October 27, 2017

**RE: ADU14-003, CAO17-005, SHL17-007-004, Second Review Letter  
Land Use Applications for proposed home, ADU driveway and retaining wall  
construction within a steep slope along the shoreline for the Lady Bug Trust.  
DEV17-009 Impervious Surface Deviation Application has been withdrawn.**

RE: ADU17-003, CAO17-005, SHL17-007, SUB17-004 Second Review Letter  
Land Use Applications for proposed home, ADU, driveway and retaining wall construction within  
a steep slope along the shoreline for the Lady Bug Trust

TREE REMOVAL PLAN

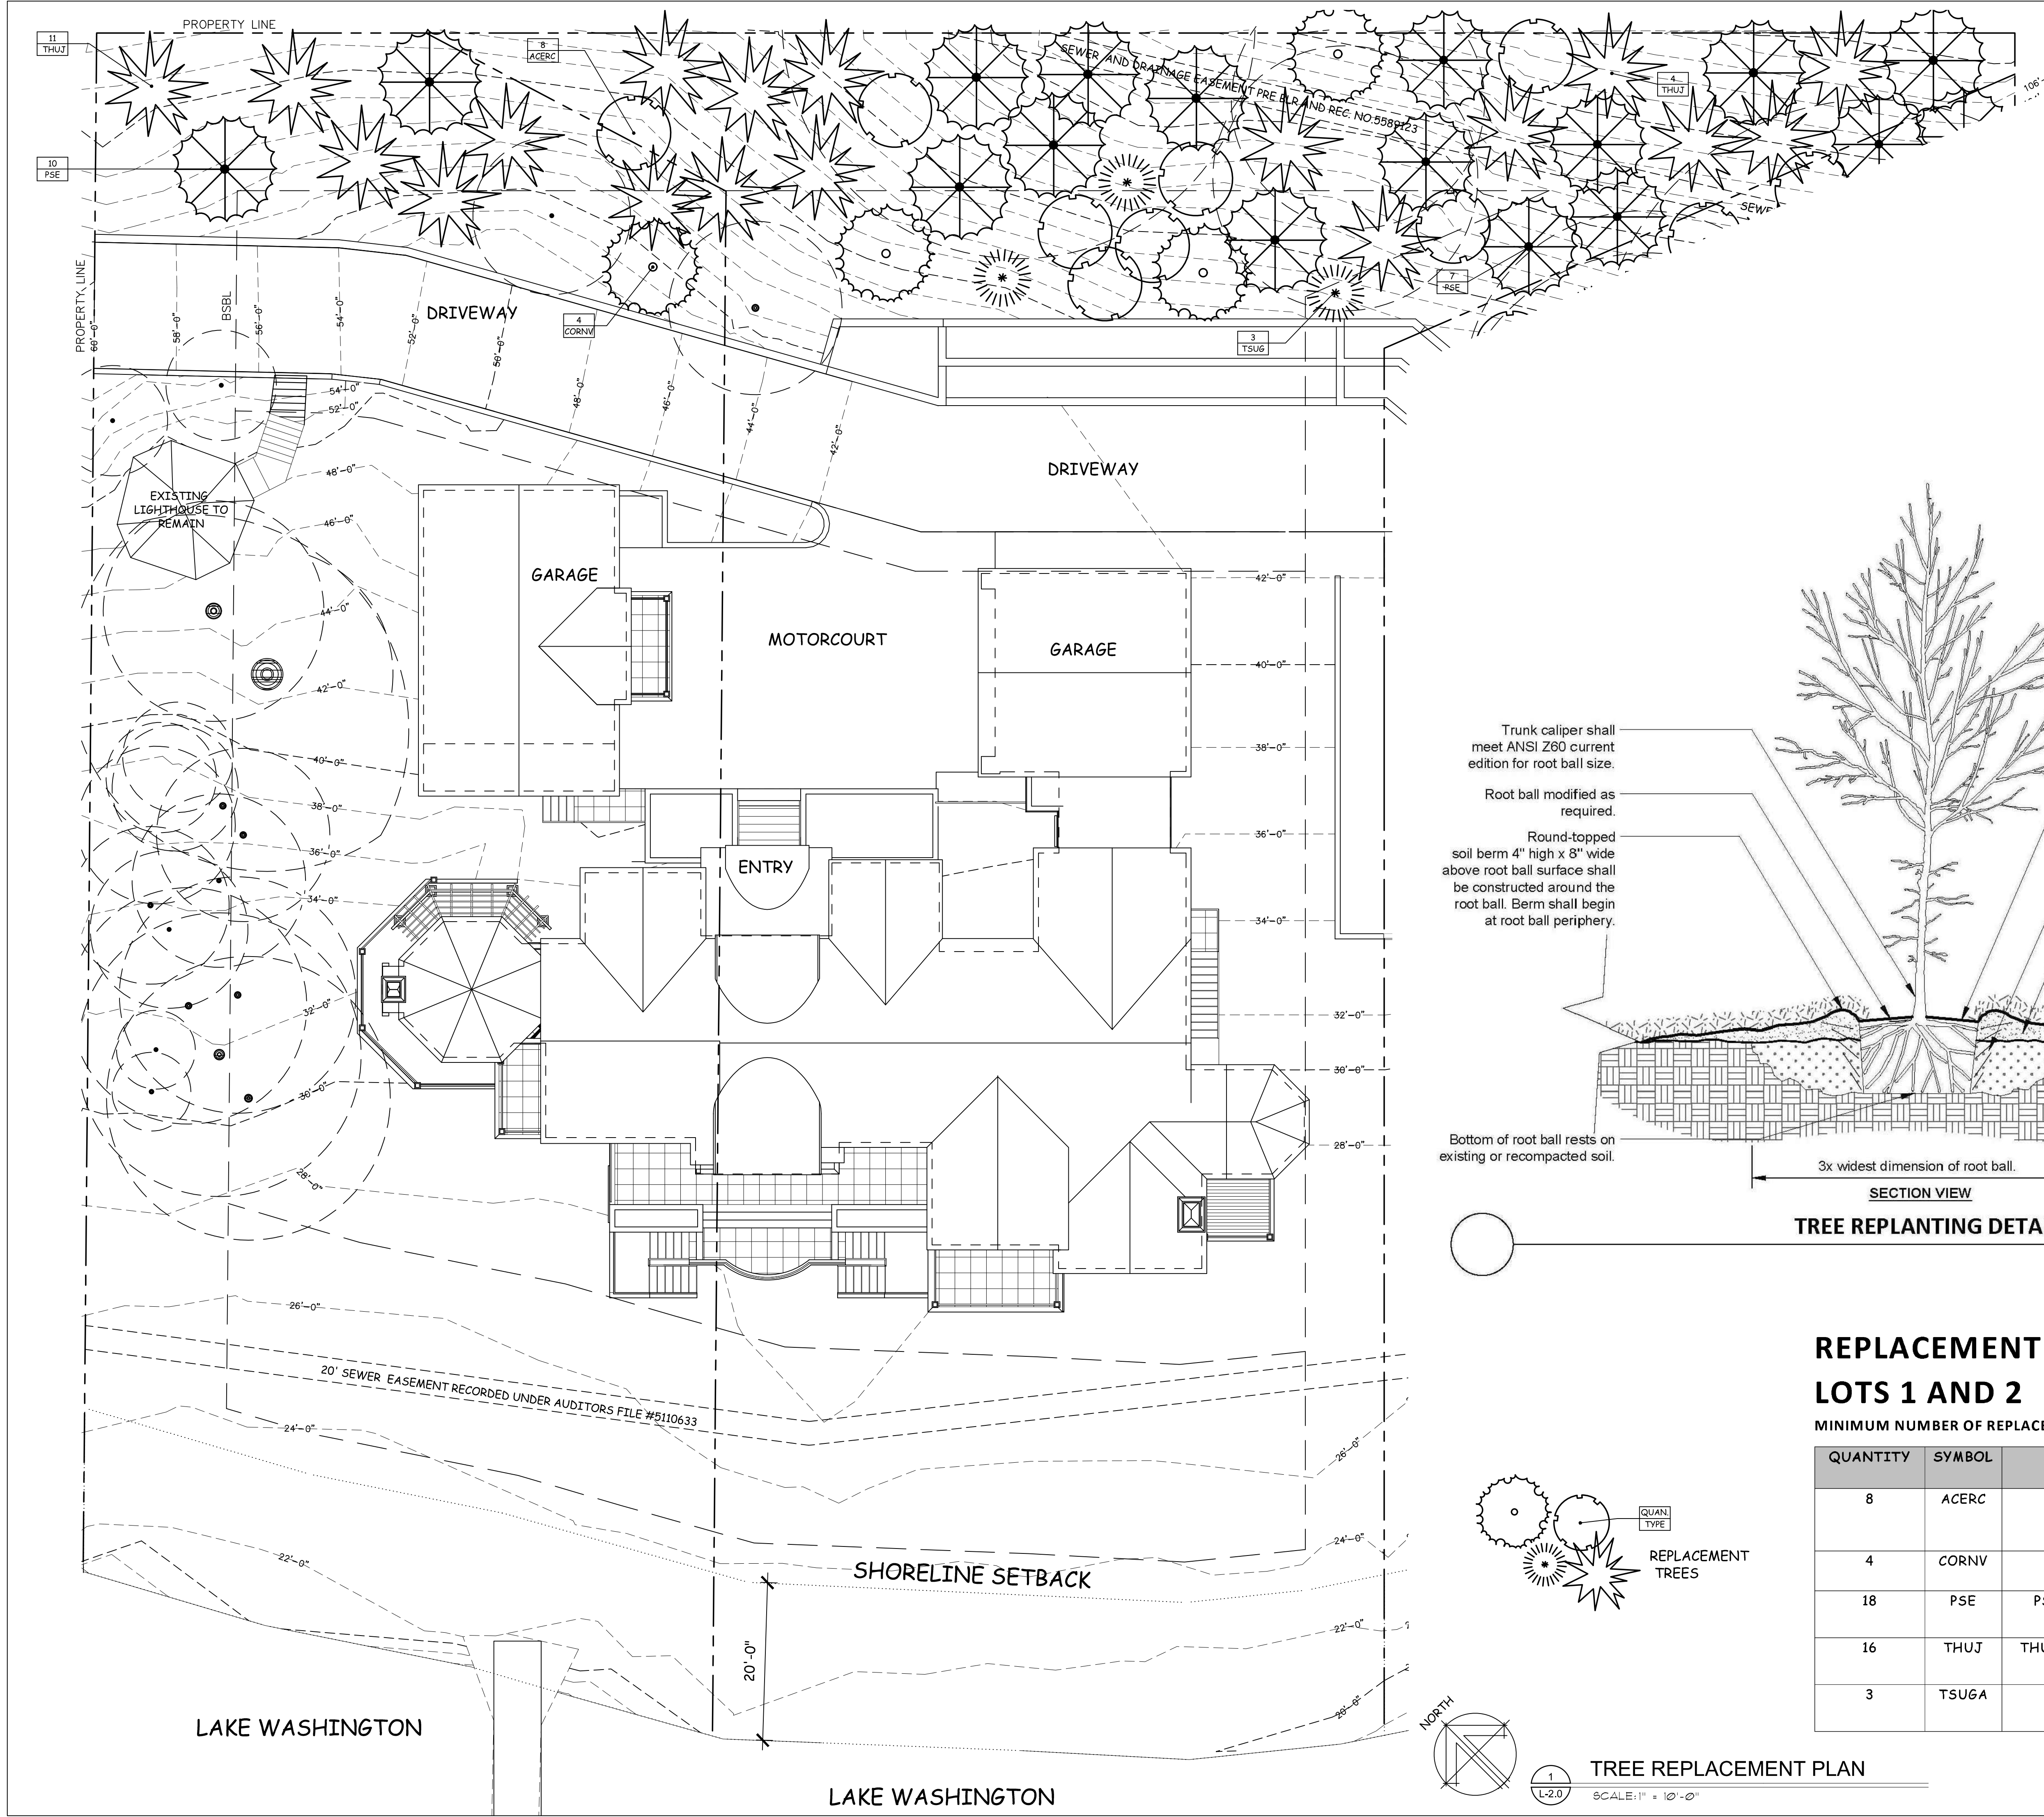
b. *This northwest property line grove of trees shall be protected as shown on L-1.0 dated 7/26/17.*

**Please see the revised L-1.0 for the grove of tree protection note.**

1 ADU - south elevation
1/4" = 1'-0"

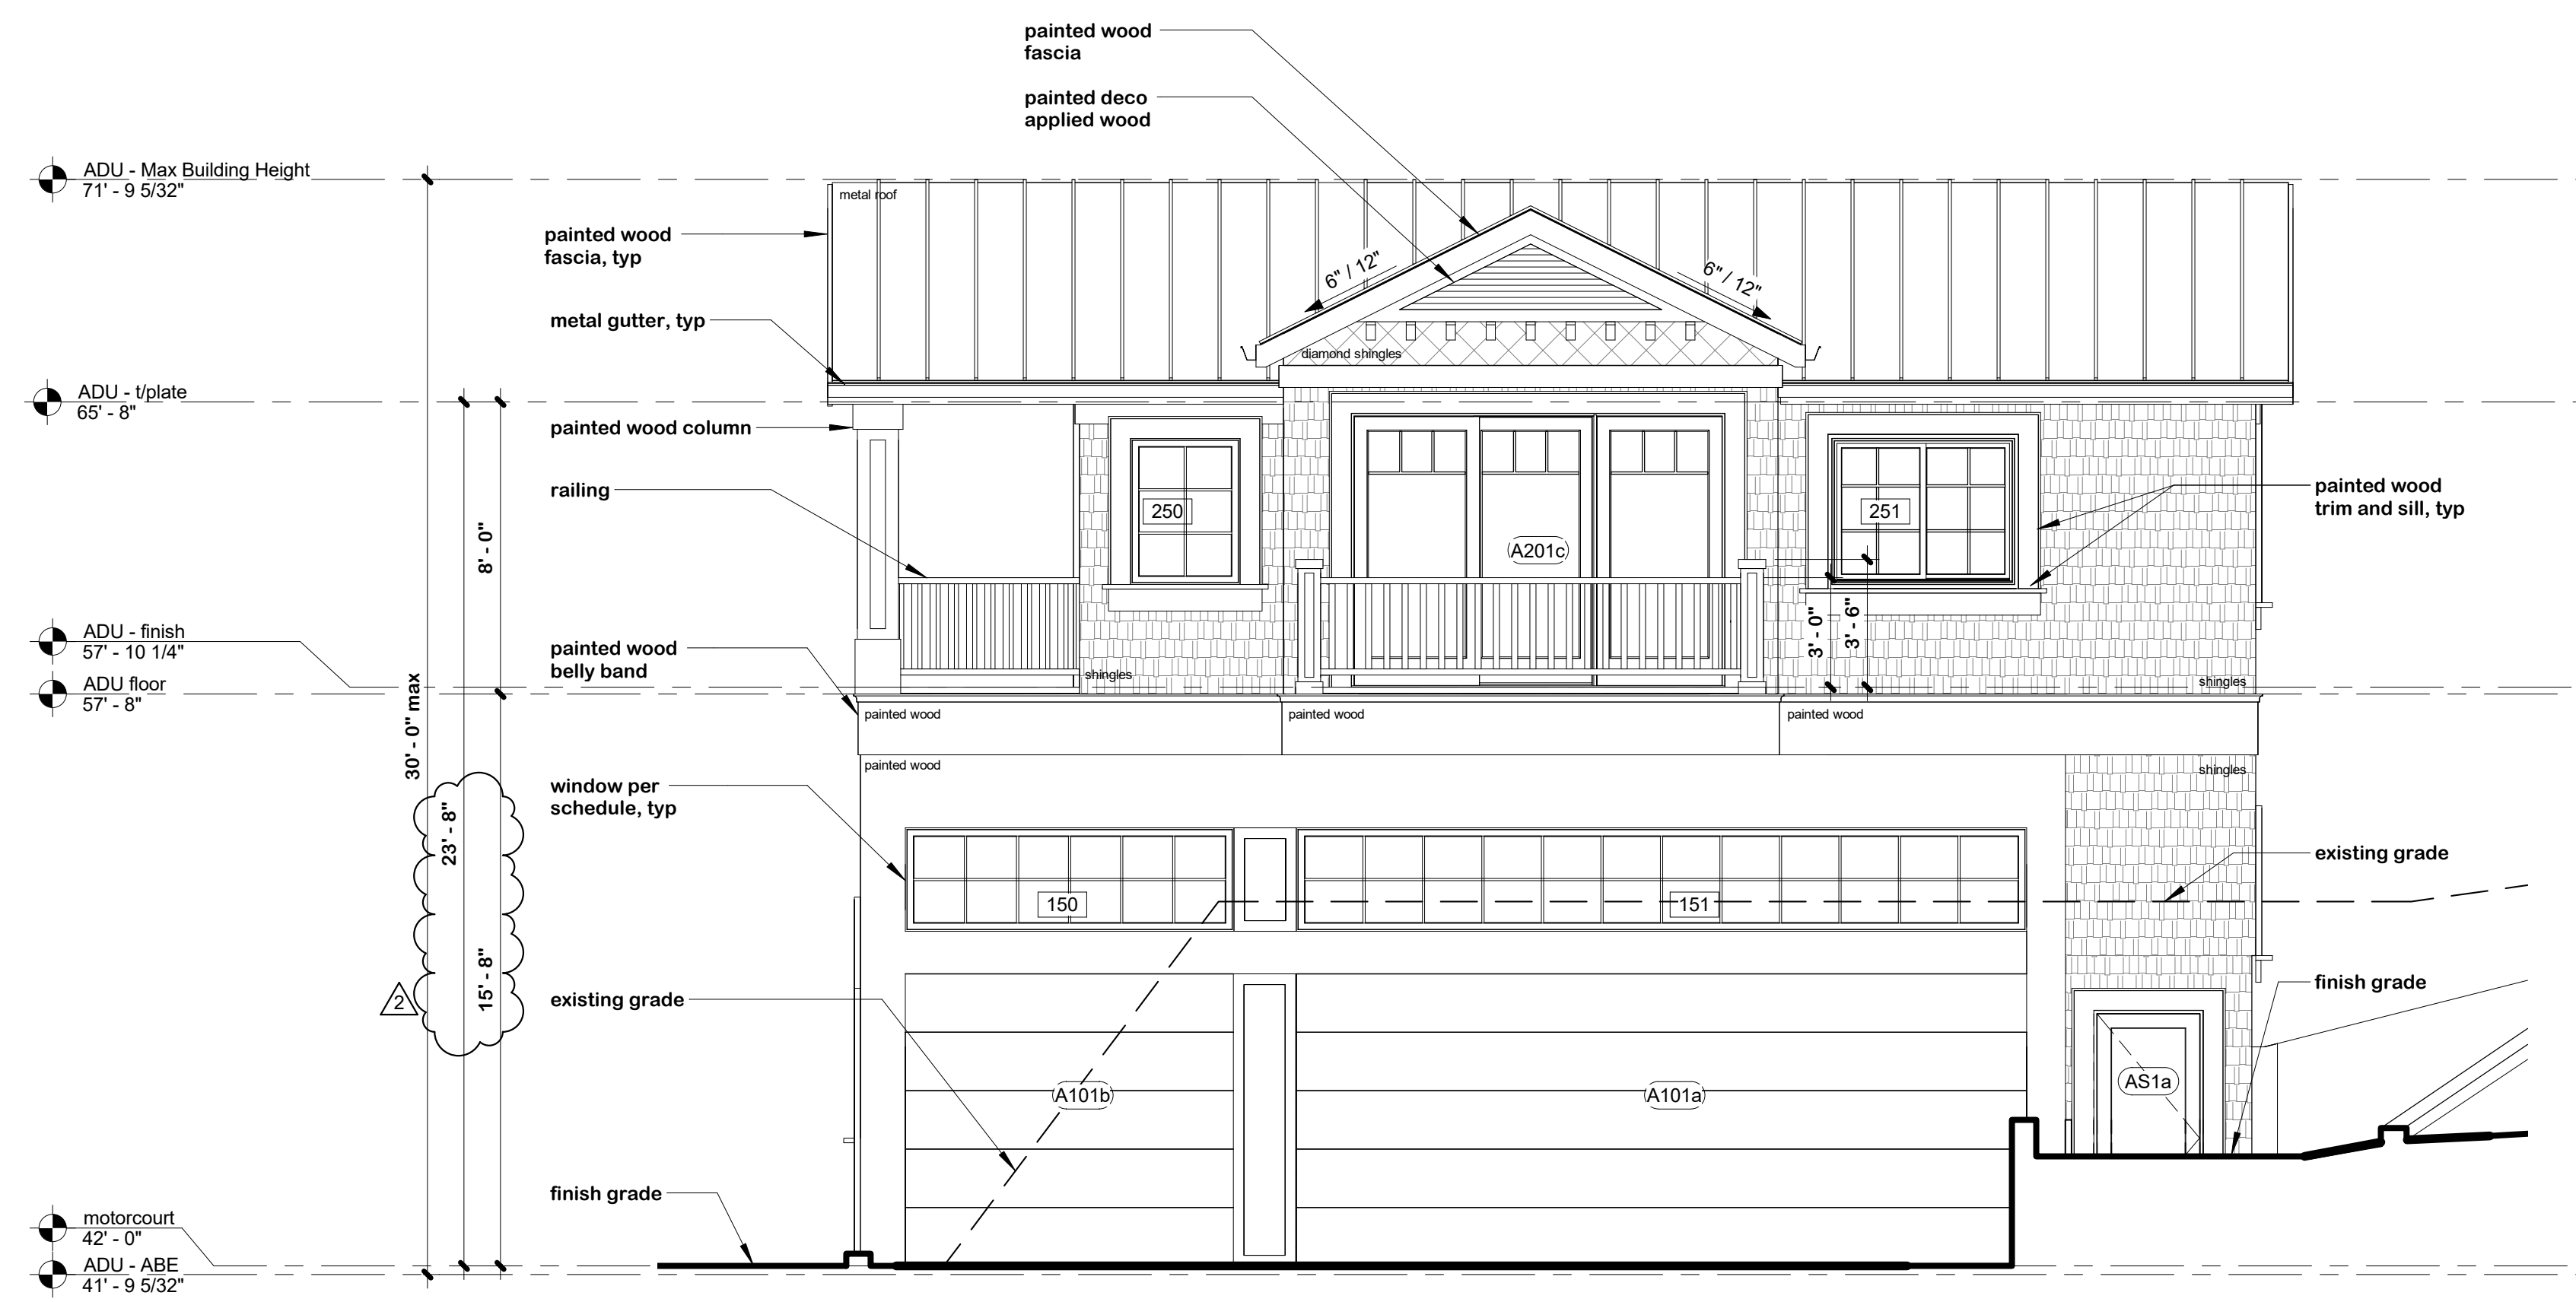
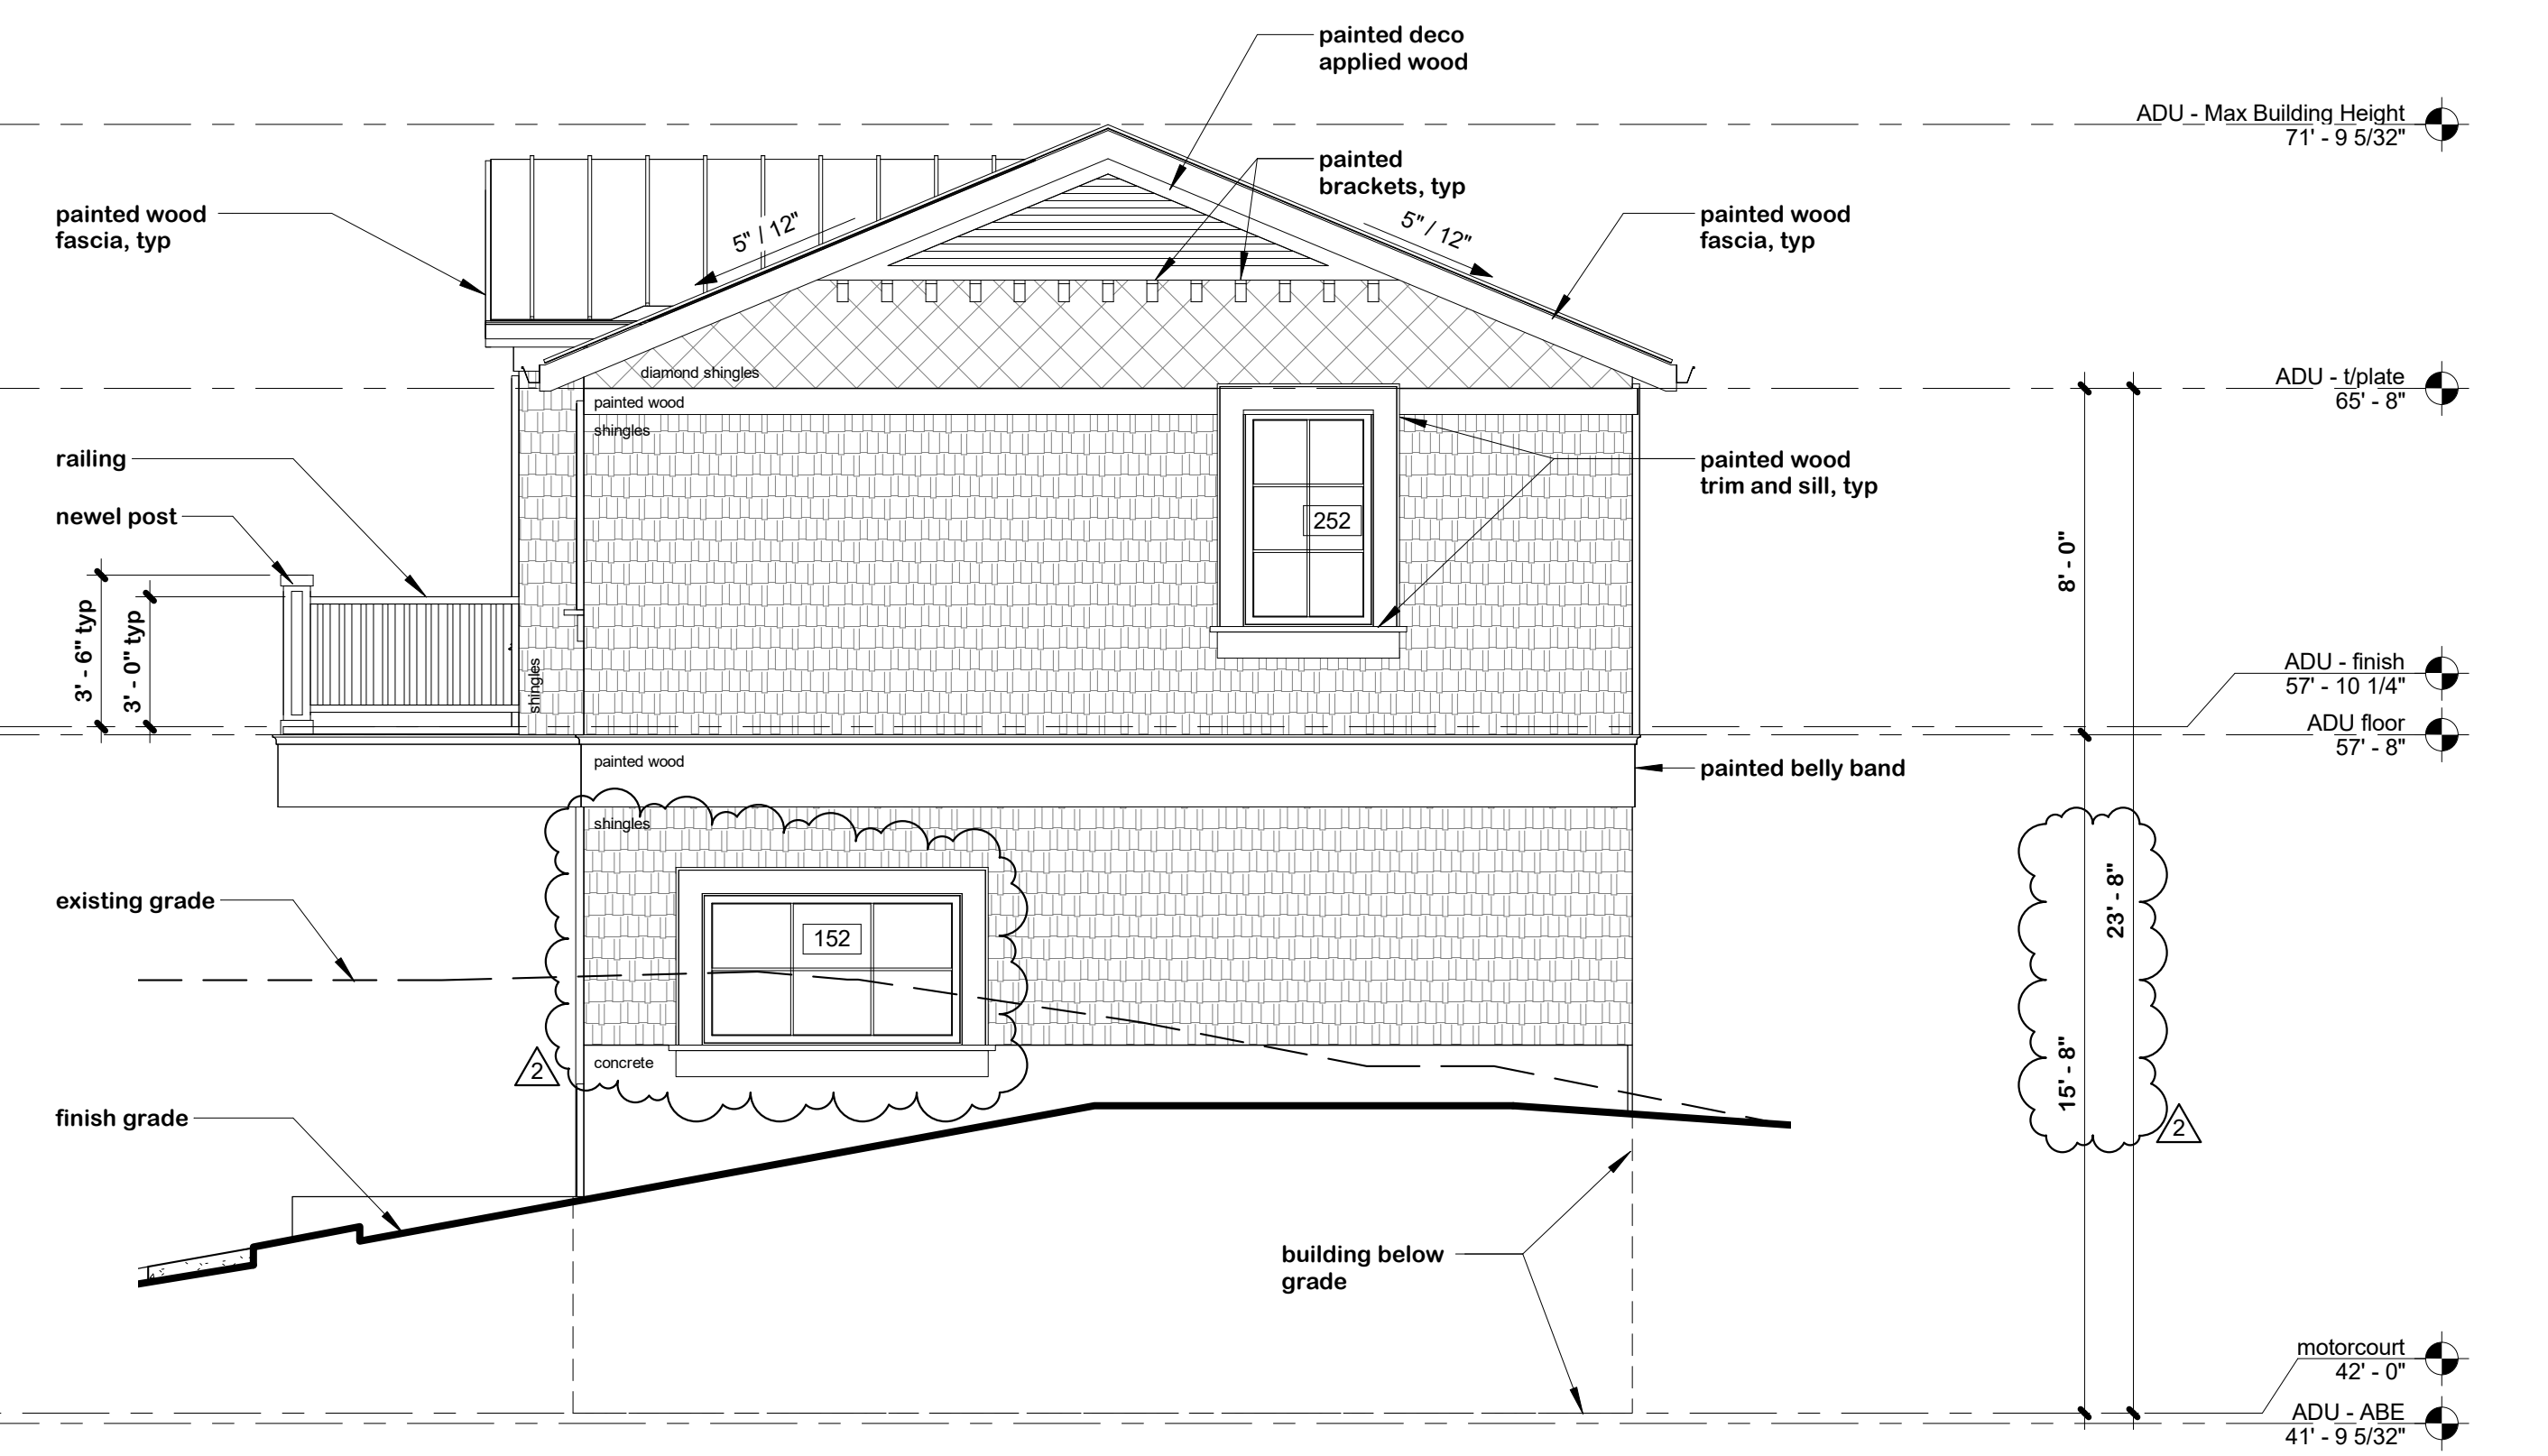
8. *Please provide building elevations drawings that the ADU shall be designed consistent with the existing roof pitch, siding, and windows of the principal dwelling unit.*

**Please see note 1 on sheet A2 of the ADU elevations. The ADU is designed consistent with the main house.**
